# Statement of Common Ground with Beverley and North Holderness Internal Drainage Board (draft)

Revision 2 (tracked)

August~~September~~ 2025

#### Figure 3.6: Indicative Culvert Crossing Points

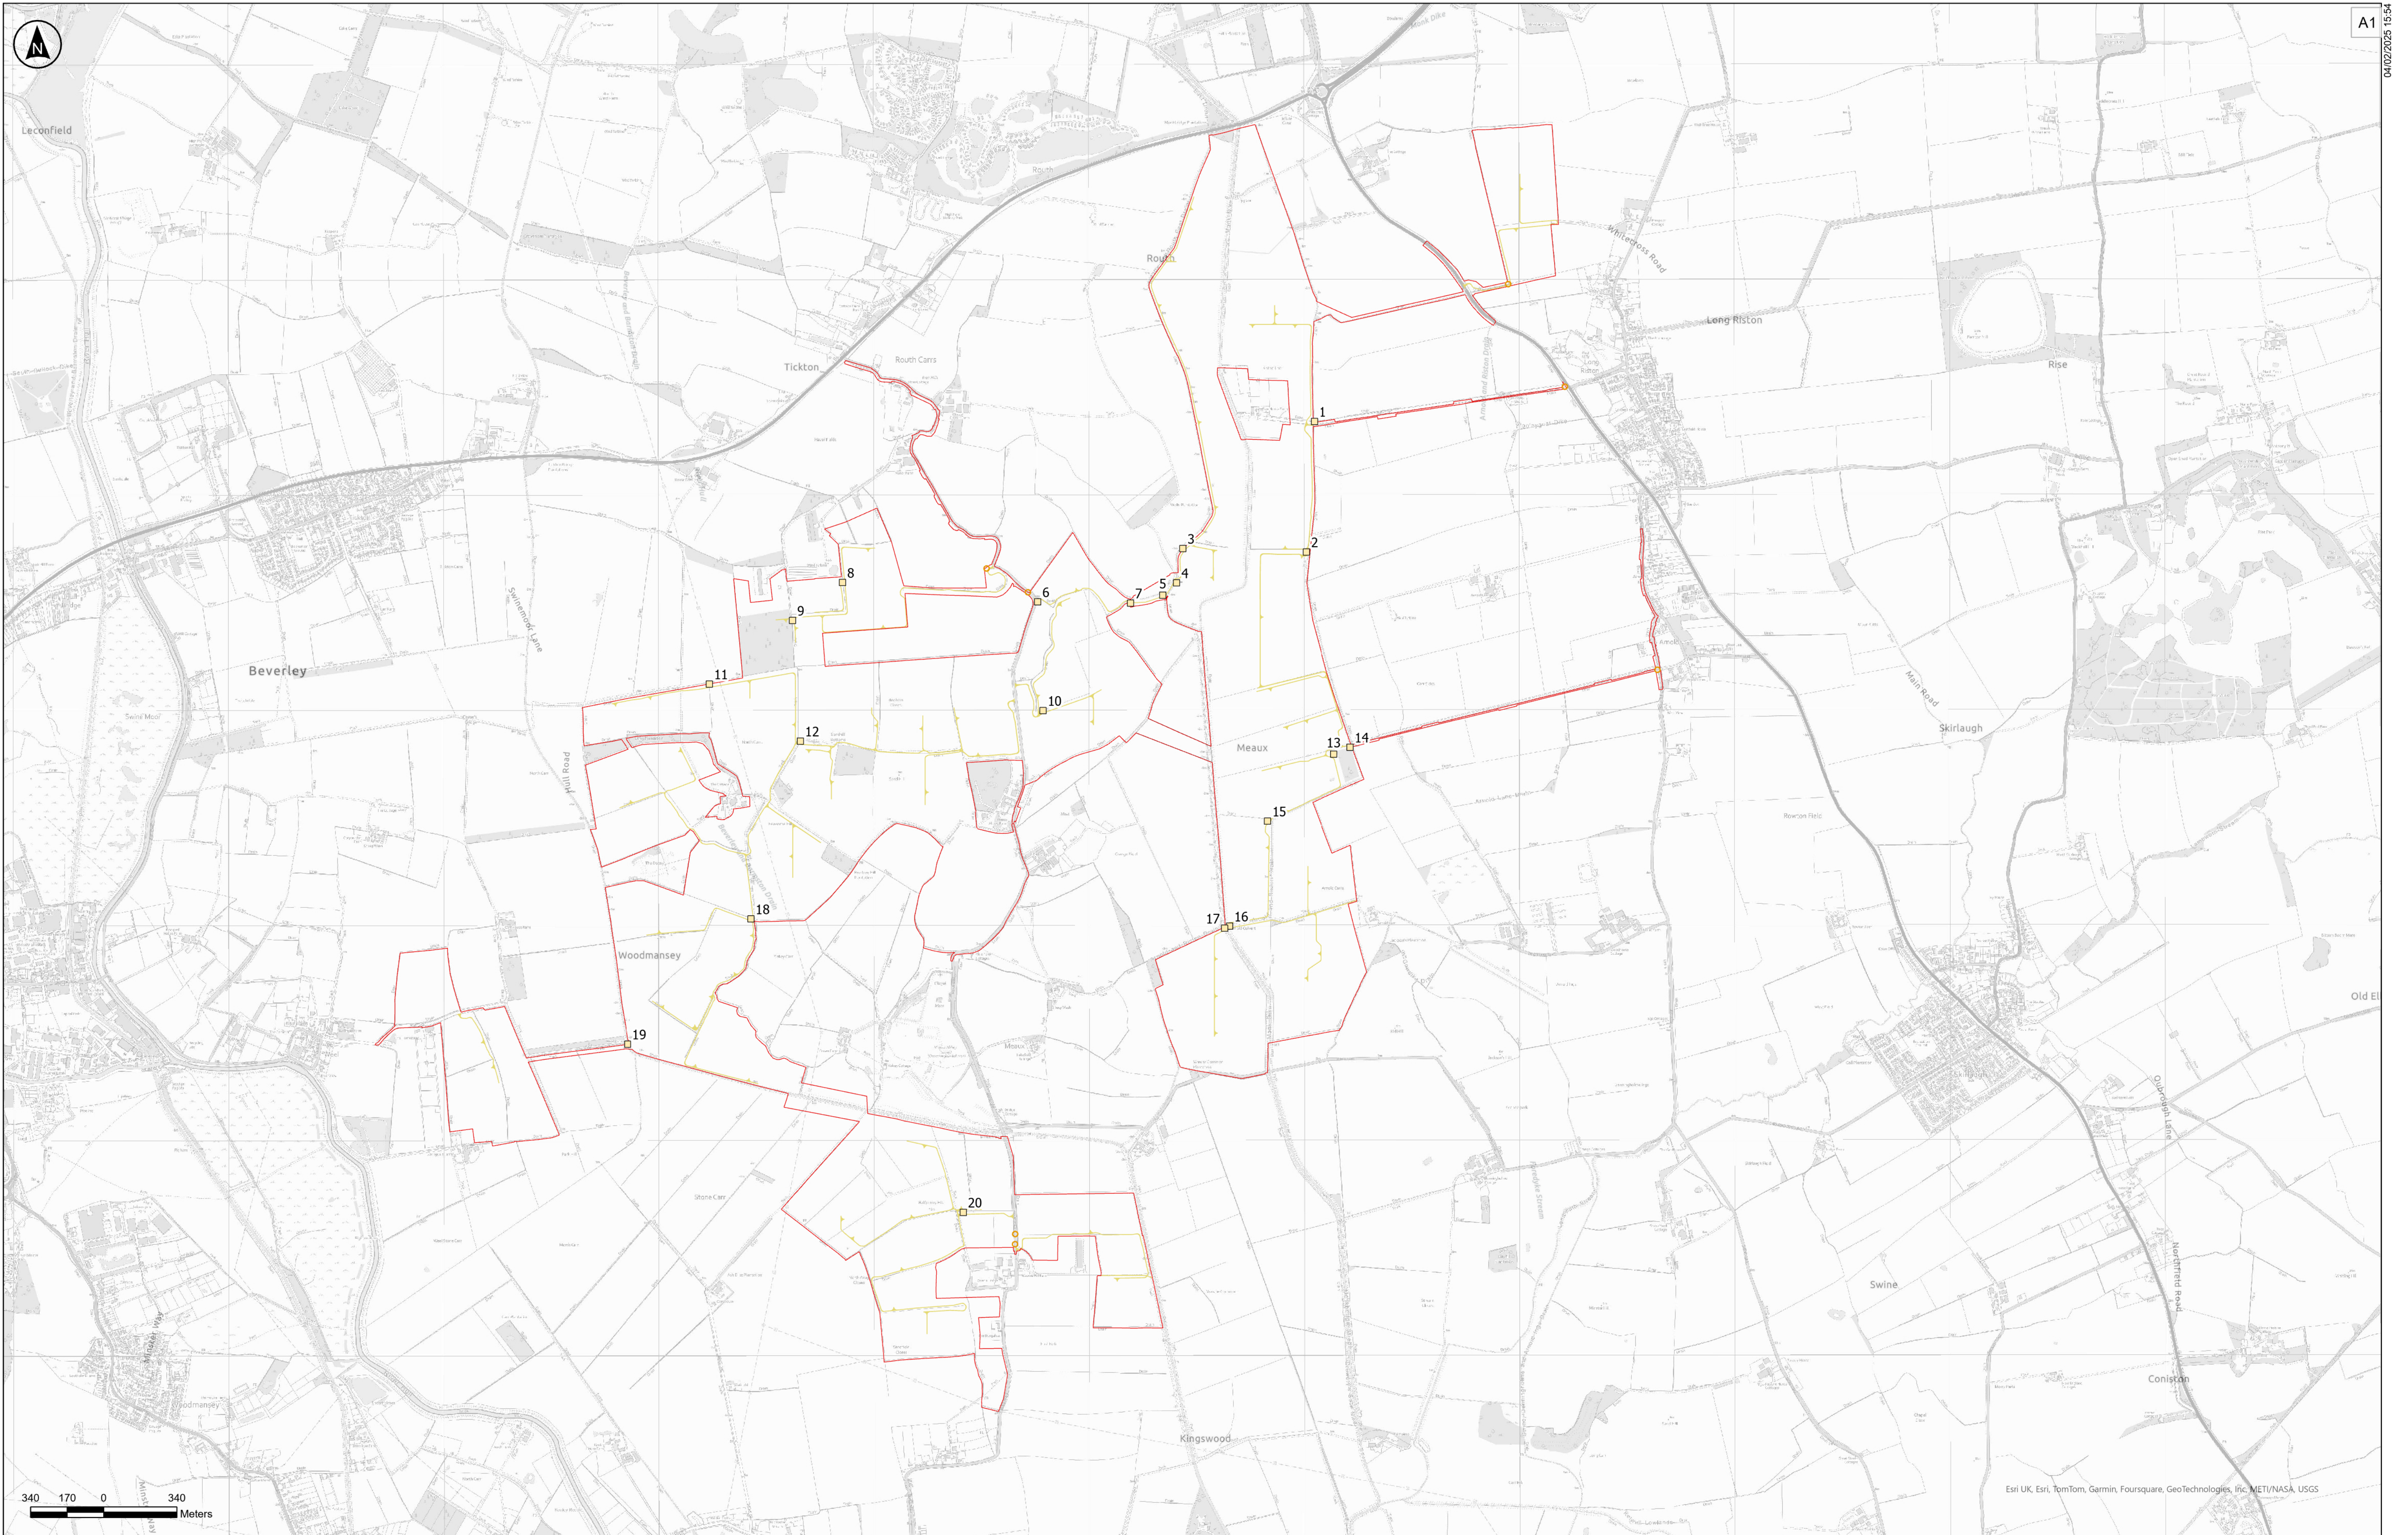
Ref	Topic	Beverley and North Holderness Internal Drainage Board Position	Applicant's Position	Status
	crossings over watercourses  <i>Hydrology and Flood Risk</i>	Drainage Board requests that details of any bridge/ culvert crossings over any watercourses within its district will need to be discussed and agreed with the Board.	crossings and/or bridge structures where possible. Pre-construction structural surveys will be undertaken to determine the most appropriate crossing at each location (it is expected that the pre-construction surveys would result in the number of new crossings required to be lower than is shown on <b>ES Volume 3, Figure 3.6: Indicative Culvert Crossing Points [APP-060]</b> ). Crossing design would be controlled by the protective provisions within Part 3 of Schedule 12 to the <b>Draft DCO [EN010157/APP/3.1 Revision 4]</b> , which require plans to be submitted to the Board for approval at the detailed design stage.  <b>ES Volume 4, Appendix 5.6: Flood Risk Assessment [EN010157/APP/6.4 Revision 3]</b> and <b>ES Volume 4, Appendix 5.5: Water Framework Directive Screening and Scoping report [EN010157/APP/6.4 Revision 2]</b> have been updated to clarify the approach to watercourse crossings and are submitted at Deadline 1.
